Phone: 0300 123 6780
Email: developeras@lancashire.gov.uk
Your ref: 3/2025/0292
Our ref: 3/2025/0292/HDC/KW
Date: 09 May 2025

Location: Mellor House Primrose Lane Mellor Blackburn BB1 9DN
Proposal: Proposed replacement dwelling, annexe and garage to include link extension and pergola above garage. Creation of new vehicular access
Grid Ref: 366331 431446

Summary

project	project number	drawing number
mellor house	24.09	21
name		
proposed - plans		
scale	date	status
1 to 100 @ A1	april 25	planning application
		revision
		A

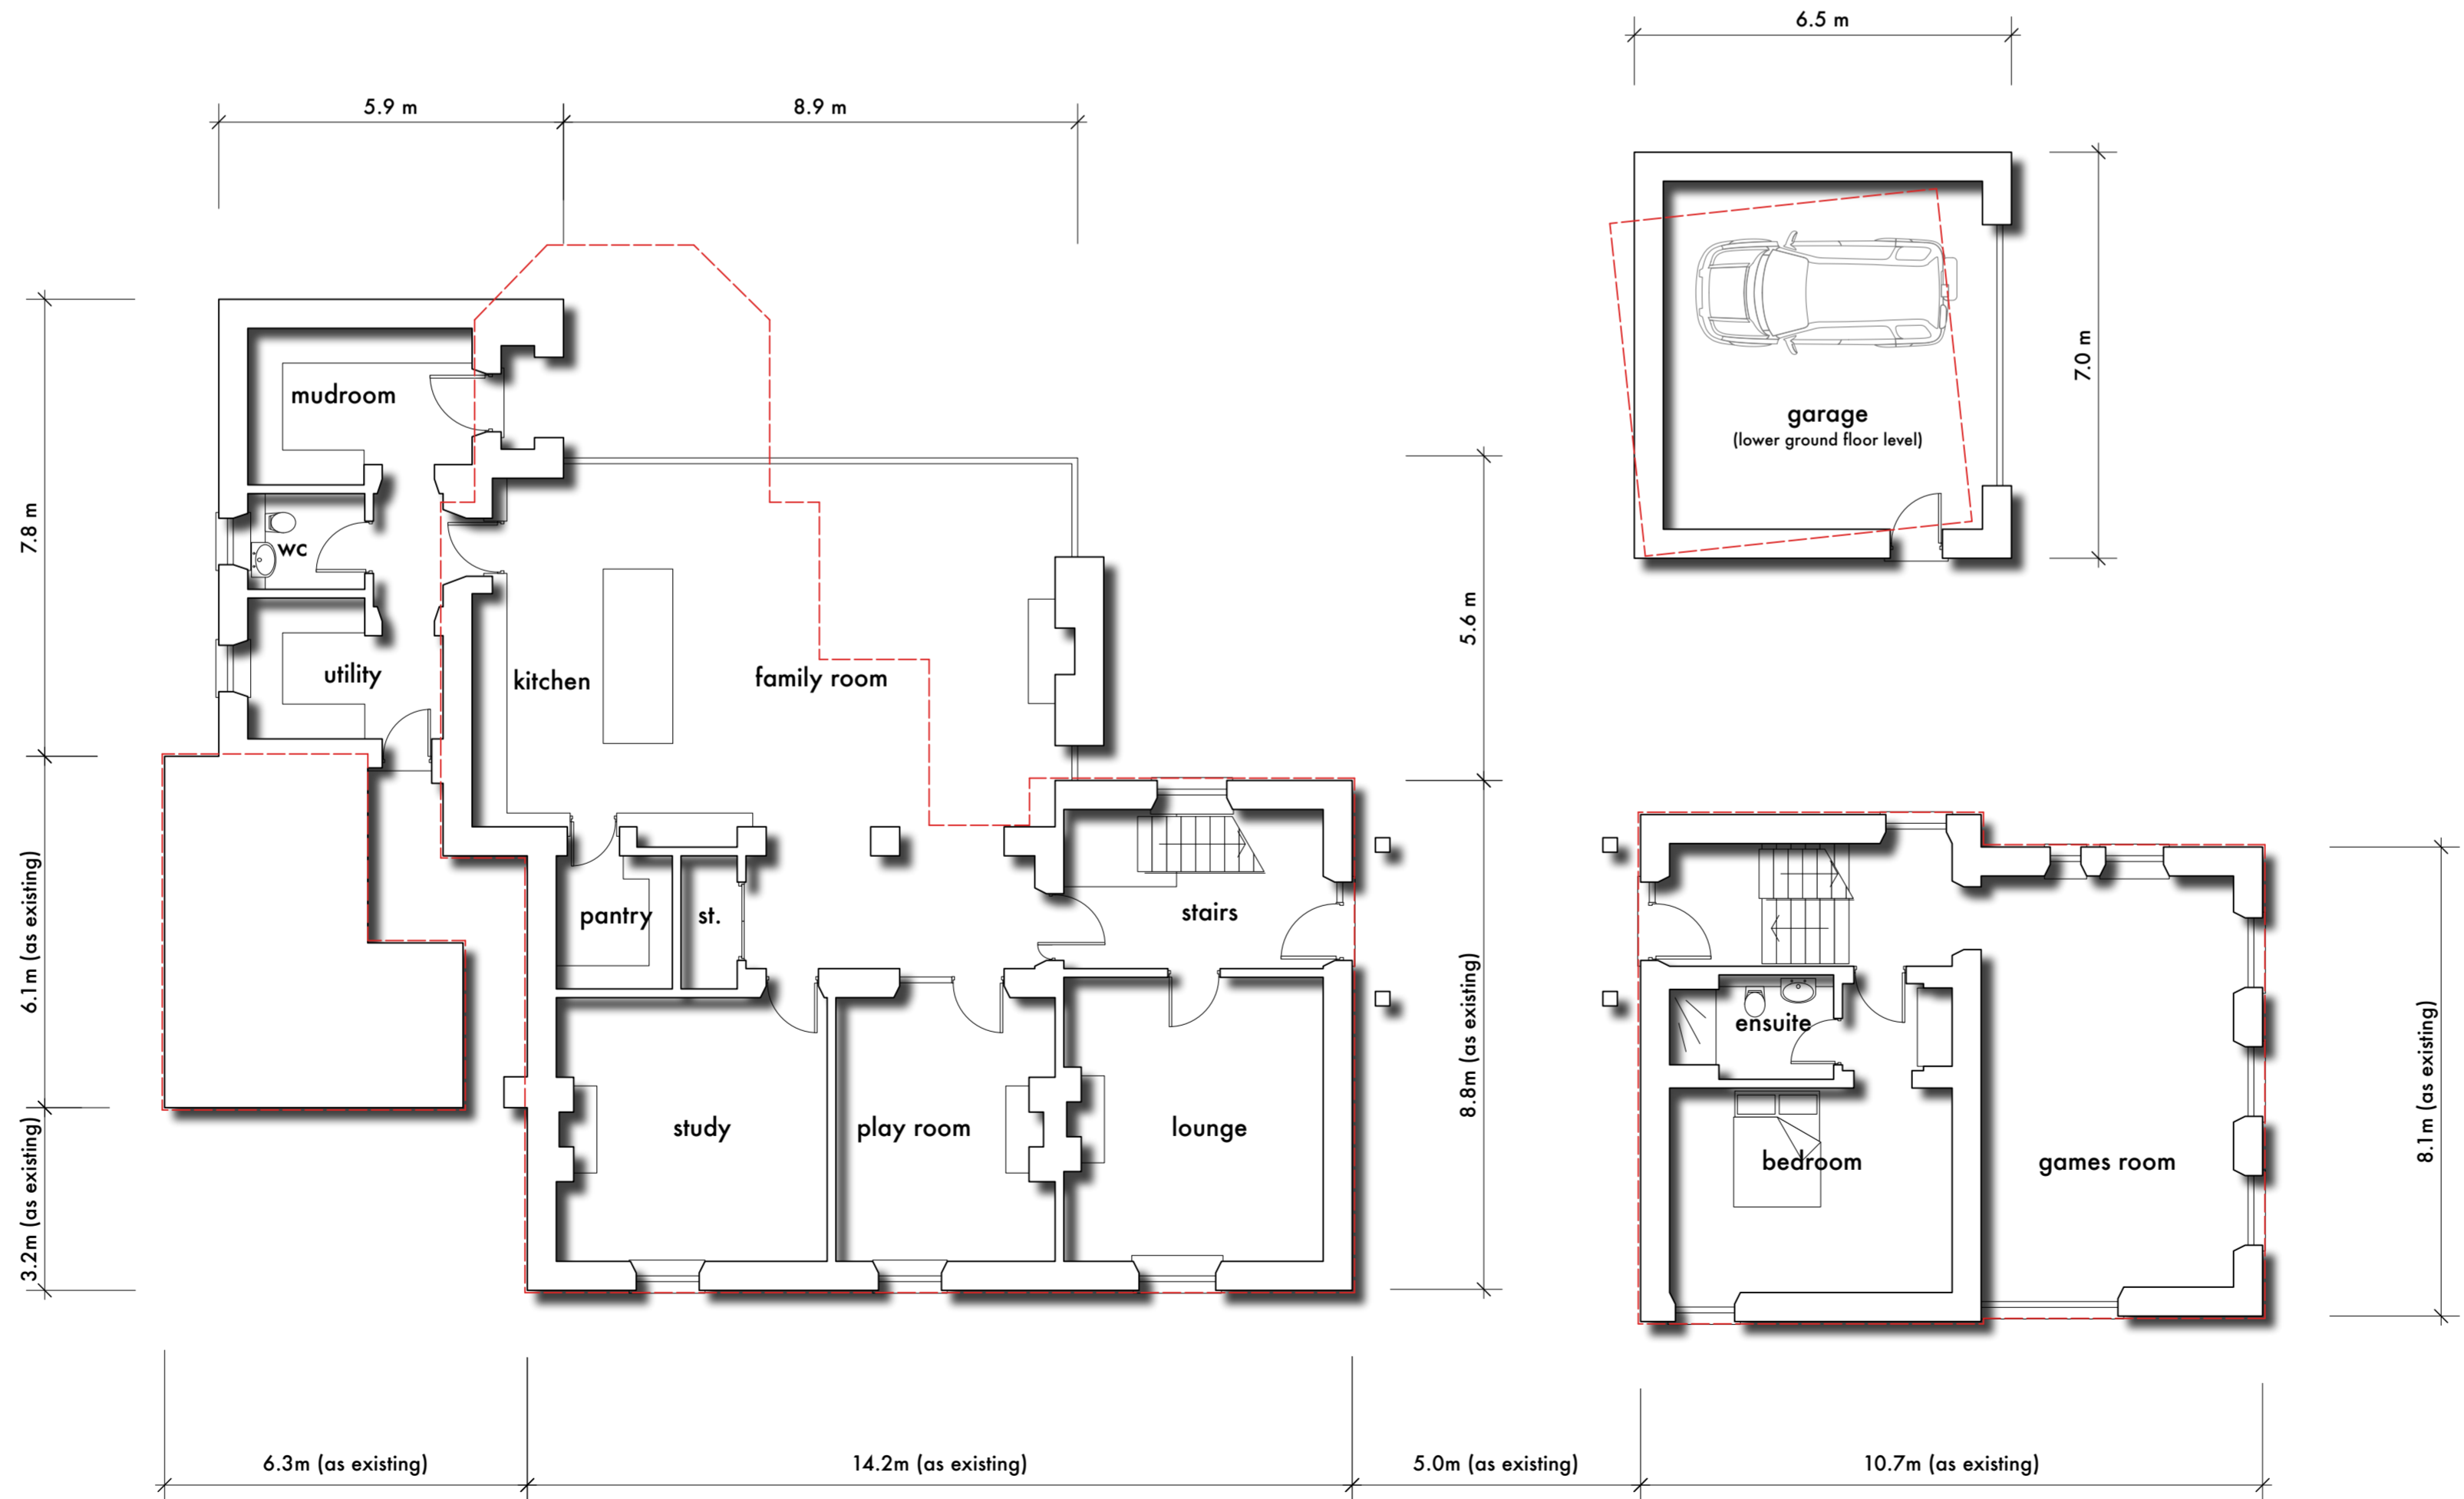
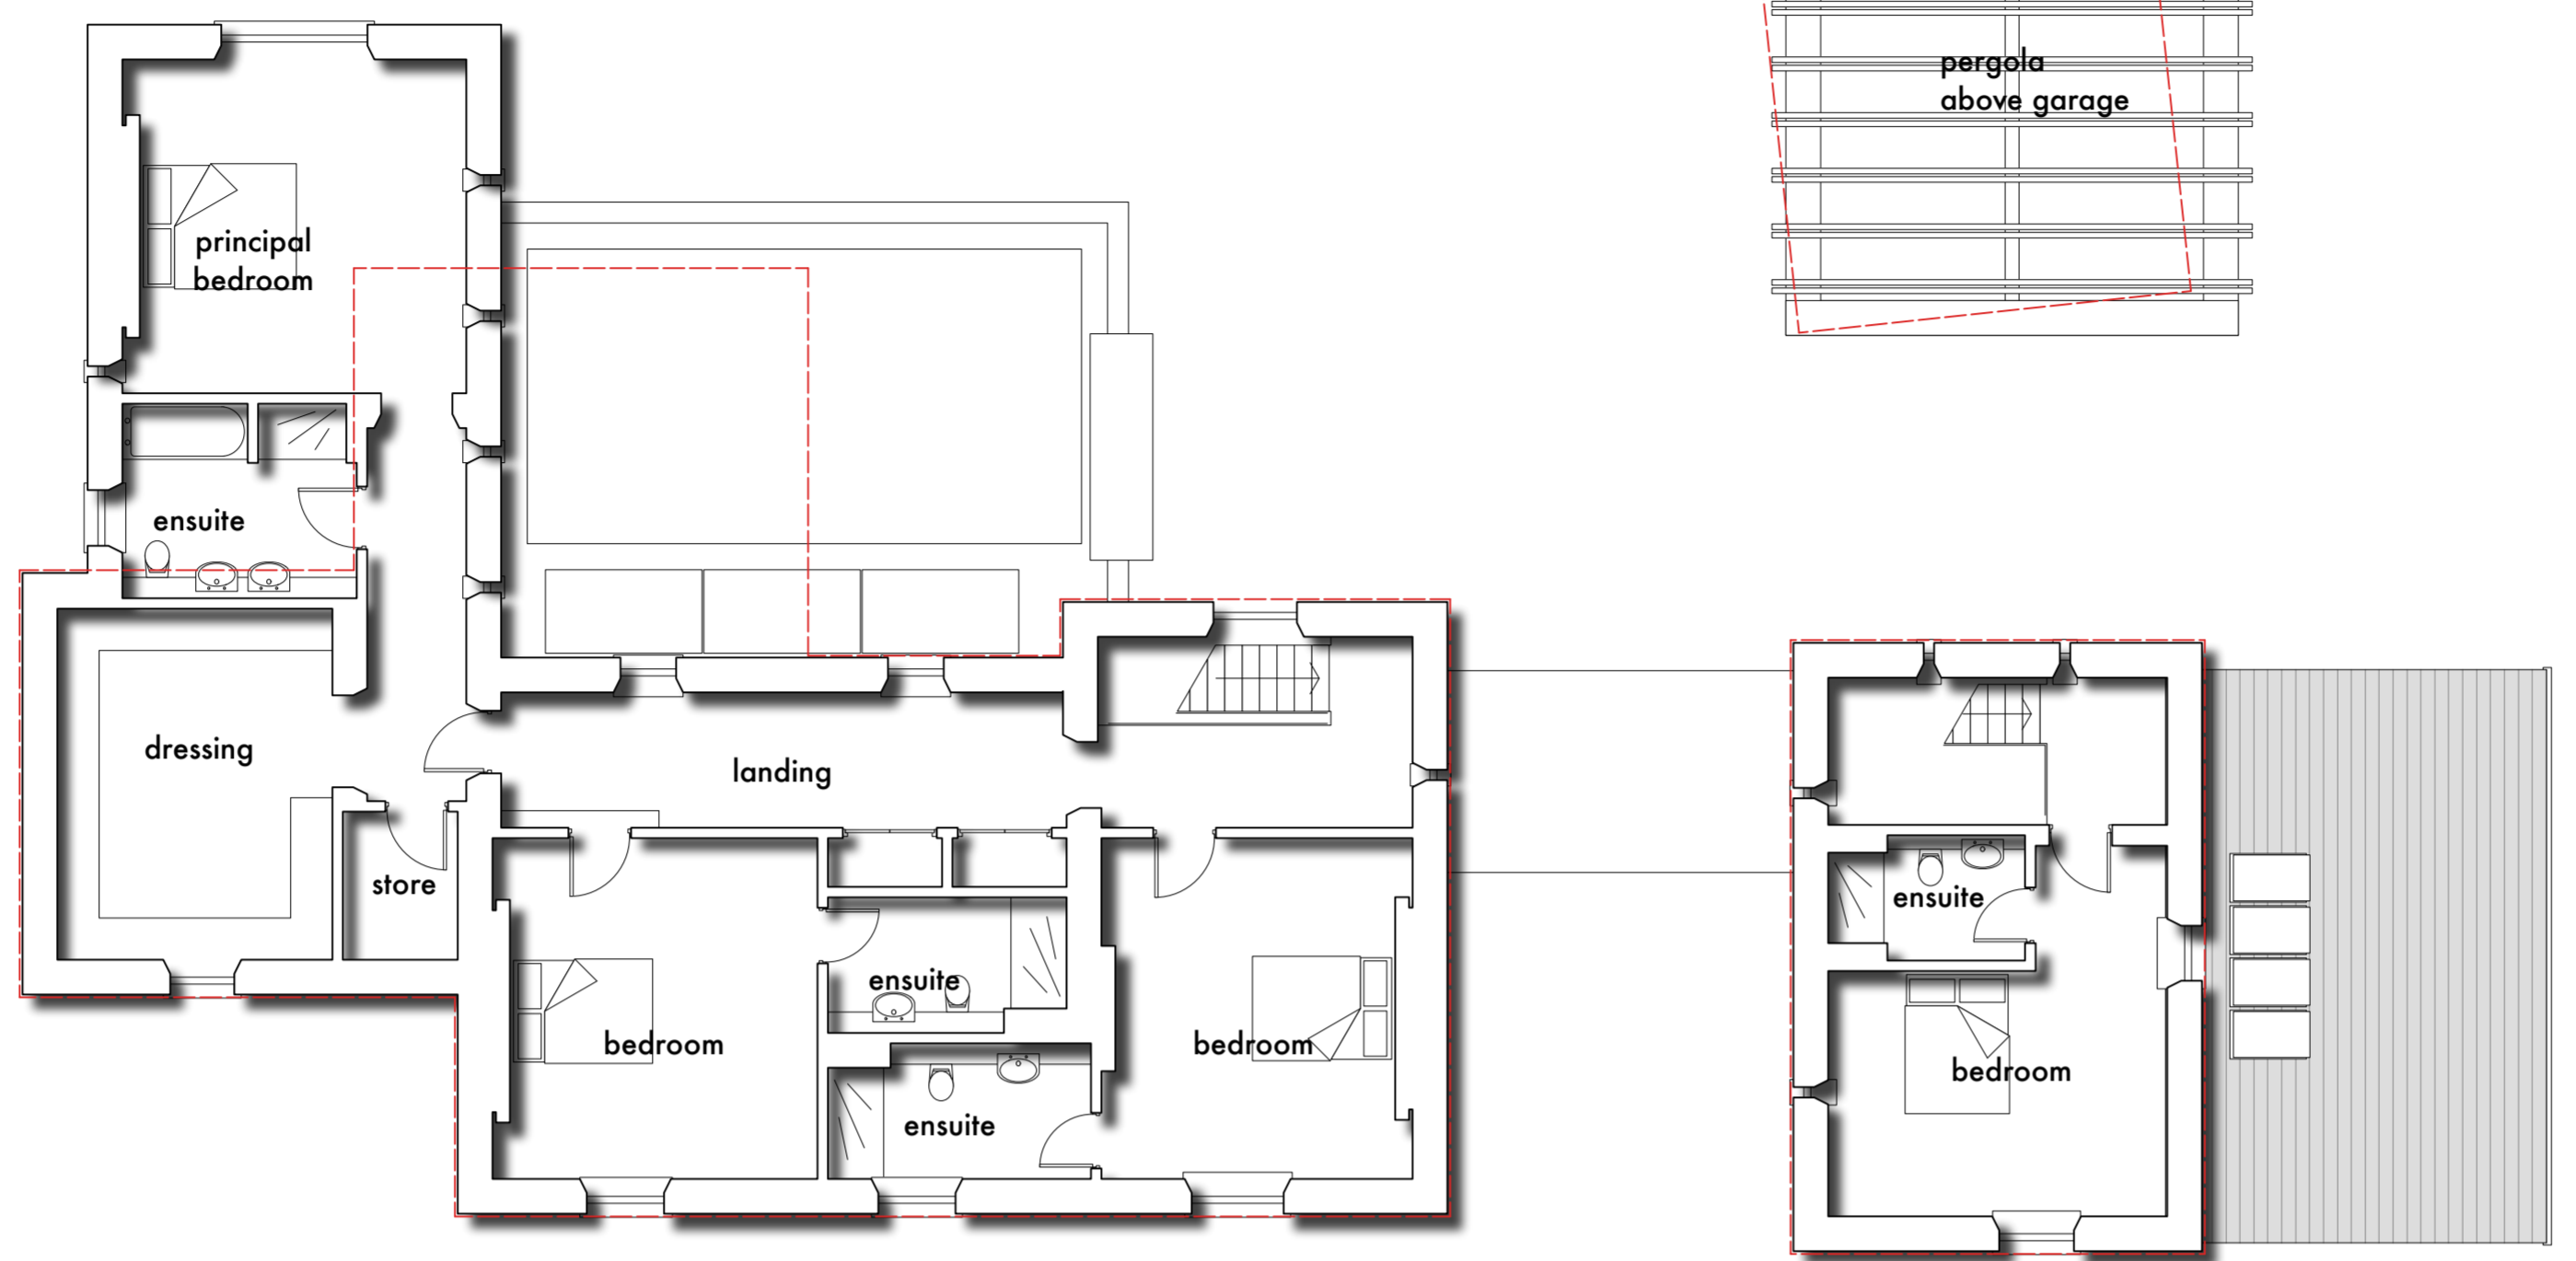
The LHA also reviewed the drawing titled proposed – plans, drawing number 21, Revision A and noted that the proposed garage does not meet the LHA recommended minimum internal dimensions for a single garage size which is 6m in length and 3m wide. The recommended distance of 6m is based on the length of a large family car (Ford Mondeo Estate 4.58m long), clearance at the rear of the car (200mm), overhang of the garage door (600mm) and room to stand in front of the car and open/close the garage door (600mm). Where garages are smaller than the recommended minimum internal dimension of 6 x 3m they should not be counted as a parking space.

Whilst the garage does not provide adequate space for parking provisions, the garage can provide covered secure cycle storage to ensure the provision and availability of adequate cycle parking and the promotion of sustainable forms of transport. Additionally, due to the nature of the application, it is expected that a charging point for electric vehicles is included in the development to promote sustainable modes of transport. The DfT guidance regarding Electric Vehicle Charging in Residential and Non-residential buildings states charge points must have a minimum power rating output of 7kW and be fitted with a universal socket that can charge all types of electric vehicles.
